From: Mark Stanwood <markstanwood32@gmail.com>
Sent: Wednesday, July 14, 2021 10:41 AM
To: Gwen Dall
Subject: Re: WWSD Rolling Hills Tank - Emergency phone numbers, onsite meeting?

From: Gwen Dall
Sent: Wednesday, July 14, 2021 8:53 AM
To: Mark Stanwood
Subject: FW: Ellicott Fire comments on Rolling Hills Tank
Attachments: 2_303_1041_Responses.pdf; Extracted pages from 102121_Tank_Full Set_020821.pdf

WIDEFIELD WATER AND SANITATION DISTRICT
ROLLING HILLS 2MG POTABLE WATER TANK
ACCESS ROAD CIVIL DETAILS

A DRIVEWAY ACCESS ROAD
C23 SCALE: N.T.S.

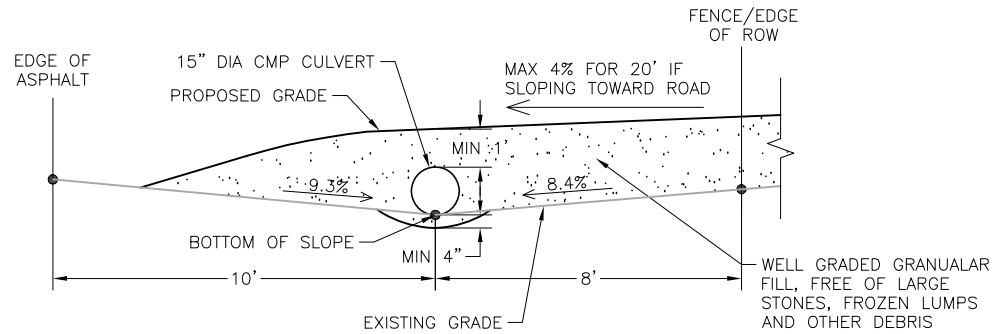
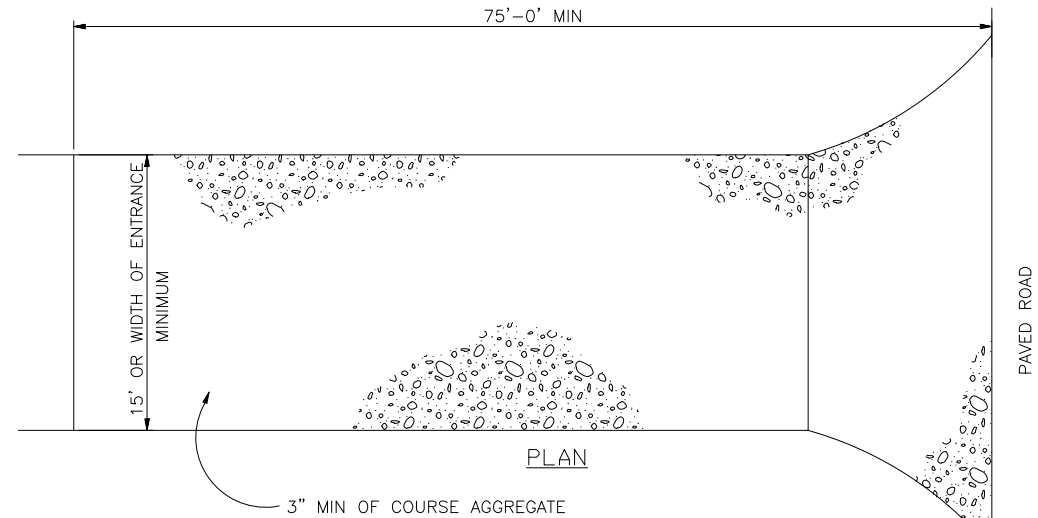
- They request that the first 30 feet of the interim access road to the tank be 20 feet wide, then the planned 15 feet wide thereafter.
- They request that site access gate be 16 feet wide

I did review your comments and did upsize the first 30 ft of my access road to the tank to 20 ft wide and then dropped it down to the original 15 ft width (see drawing C23 of the preliminary construction plans submitted). I further updated the drawing prior to my Site Development plan submittal – see attached drawing for your reference. My apologies if I missed a section.
